## **Development Facilitation Team (DFT) – Review Comments**

**Project No: PR-2022-007903 Date: 2/07/2024**

**Application For: Vacate Santa Clara Ave SE and Altez ST NE (Public Right-Of-way) as shown on maps and convert into private right-of-way**

### **Application For: SD-2024-00007 – VACATION OF PUBLIC RIGHT-OF-WAY**

PLAT OF
TRACT A1 OF BLOCK 26, LOTS 5A, 6A,
7A, 8A, 9A, 10A OF BLOCK 25
— AND BLOCK 56-A1 & 56-A2

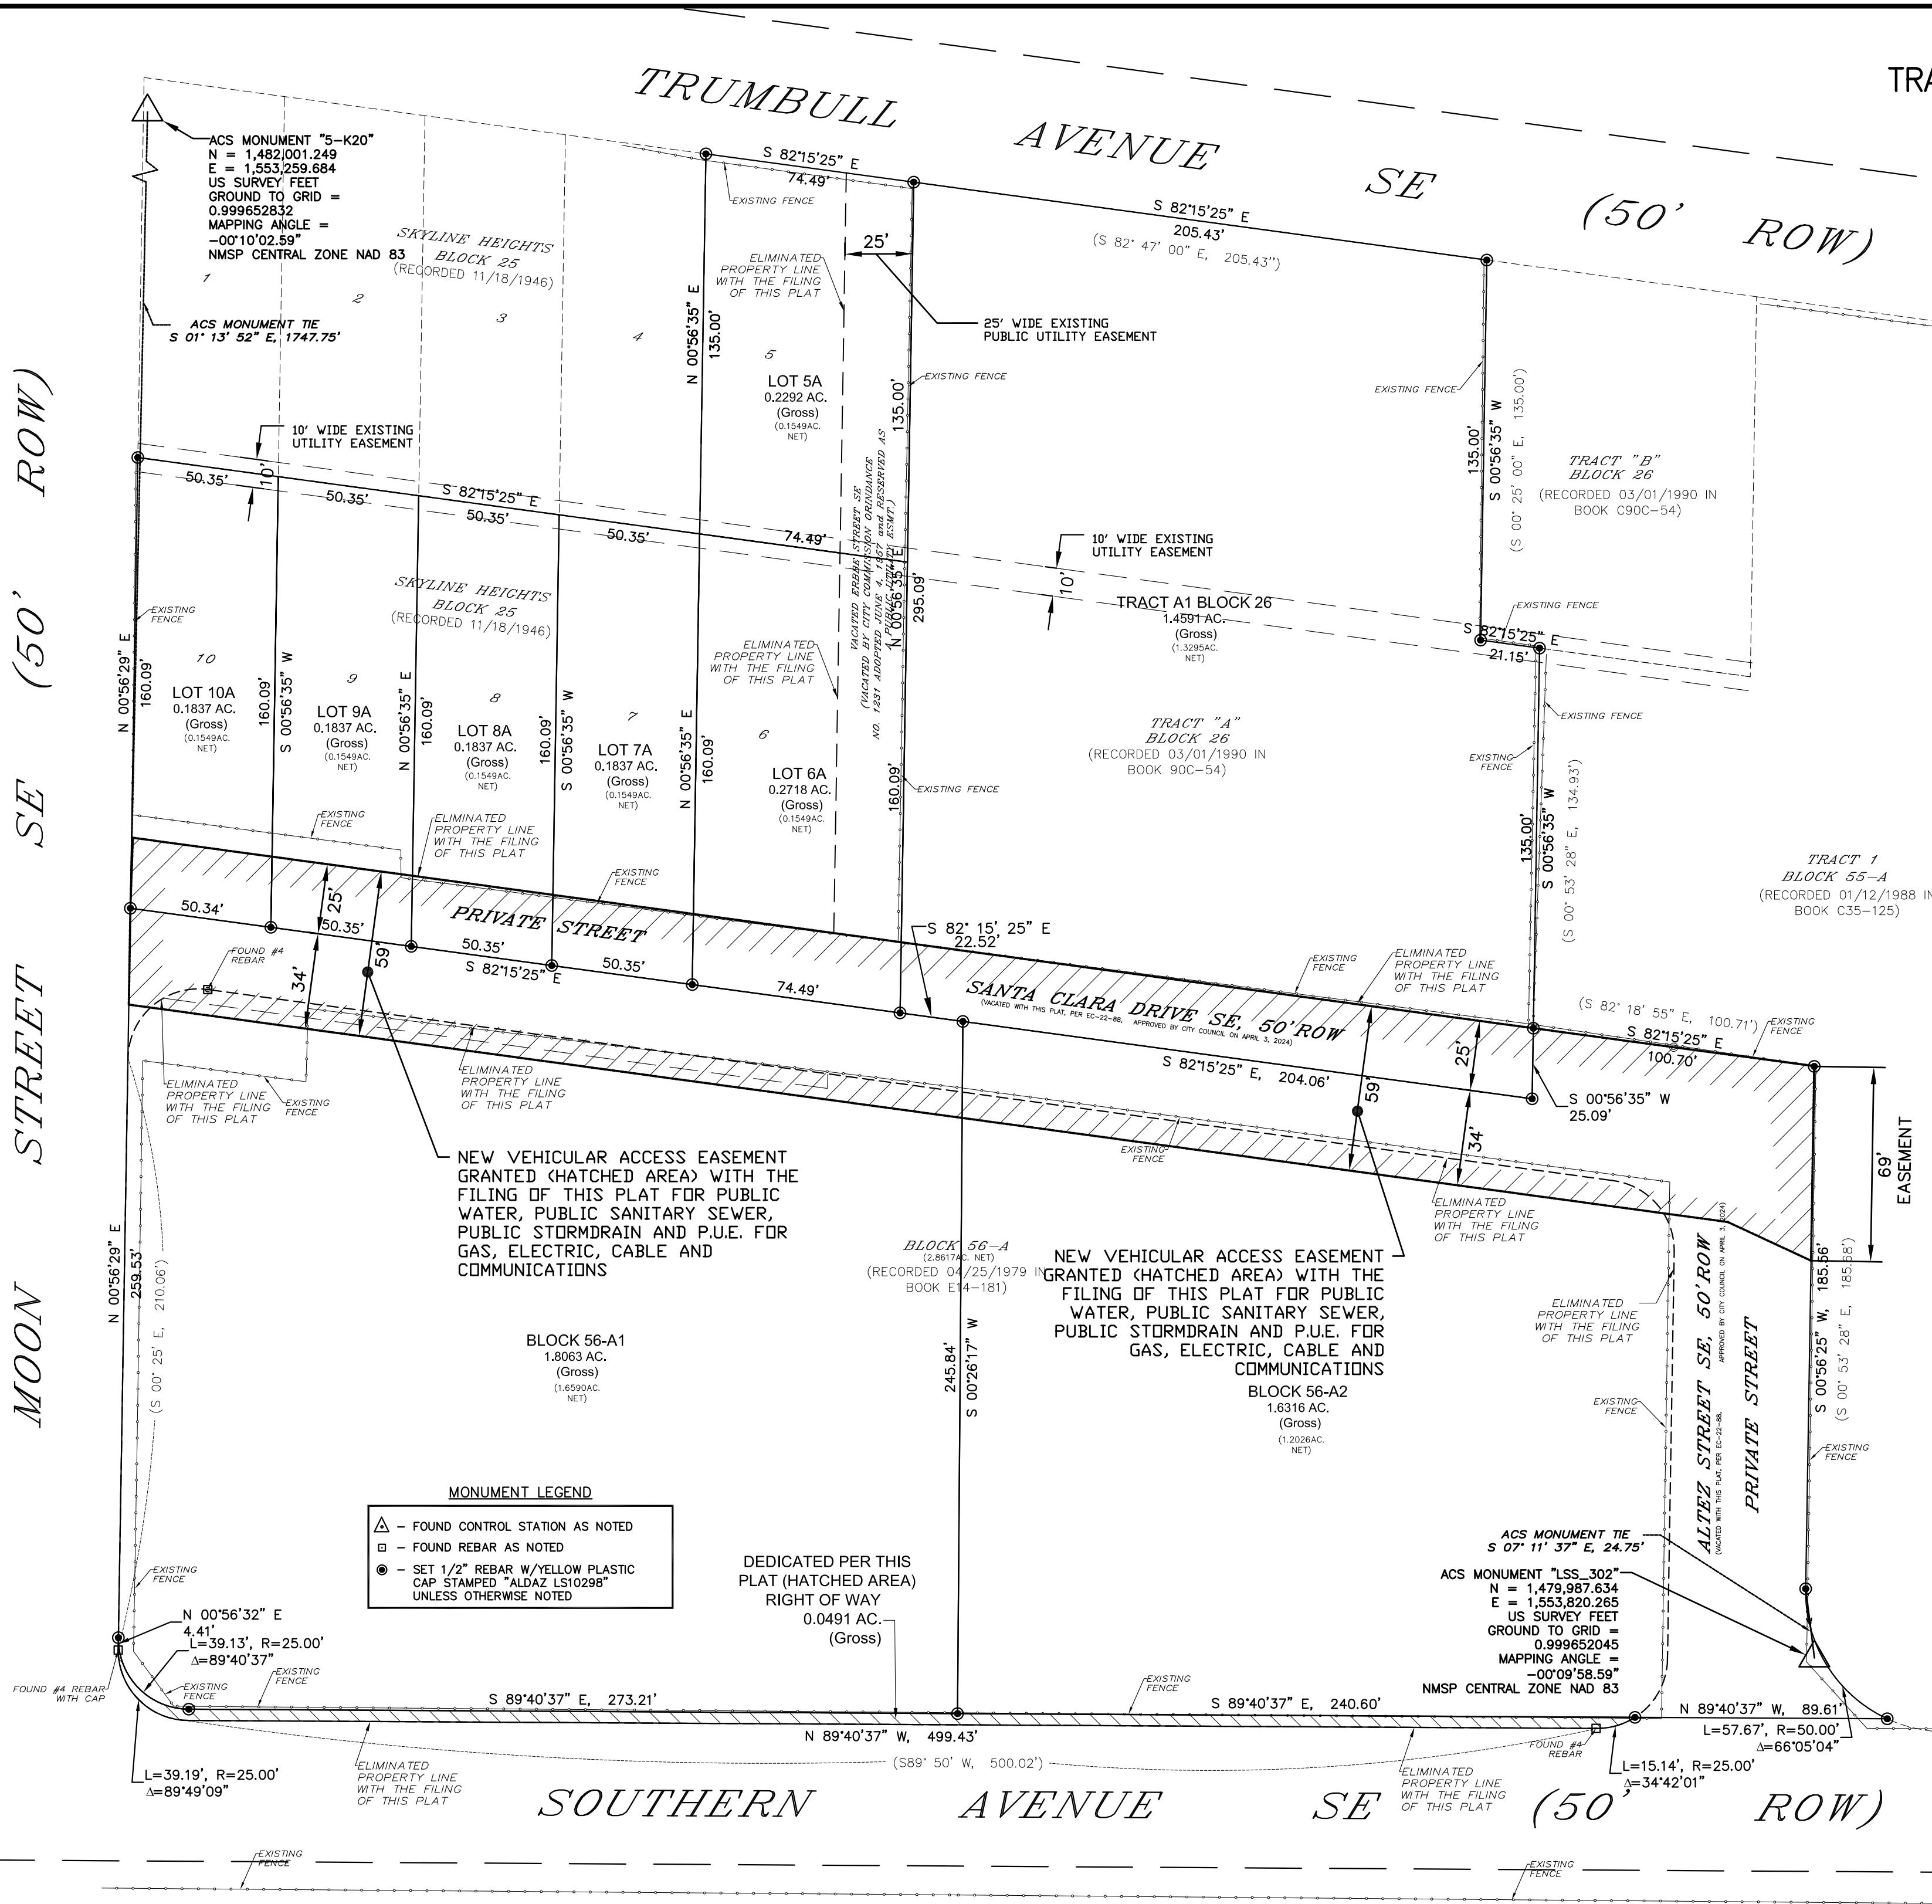
1. No objection to the proposed vacation.
  - a. Please note the corridor being vacated needs to include proper easements prior to signature of the plat. Please work with Utility Development to ensure that is completed.
  - b. Please review Sketch Plat comments and address those for the plat when that application comes in.

- Hydrology will need a Public Drainage Easement over the two existing public storm drains (a 24-in and a 48-in).
- Please add the City's standard drainage easement language to the plat.

2. Santa Clara and Altez would need to meet design requirements of a local roadway including having a 5' sidewalk with 4' to 6' landscape buffer.
3. Moon is a local road and requires a minimum 5' sidewalks with a 4' to 6' landscape buffer. Southern is a minor collector and requires a 6' sidewalk with a 5' to 6' landscape buffer.

- AMAFCA concurs with City of Albuquerque Hydrology Section regarding the requirement for a public drainage easement for maintenance of the existing storm drain system in the roadway.
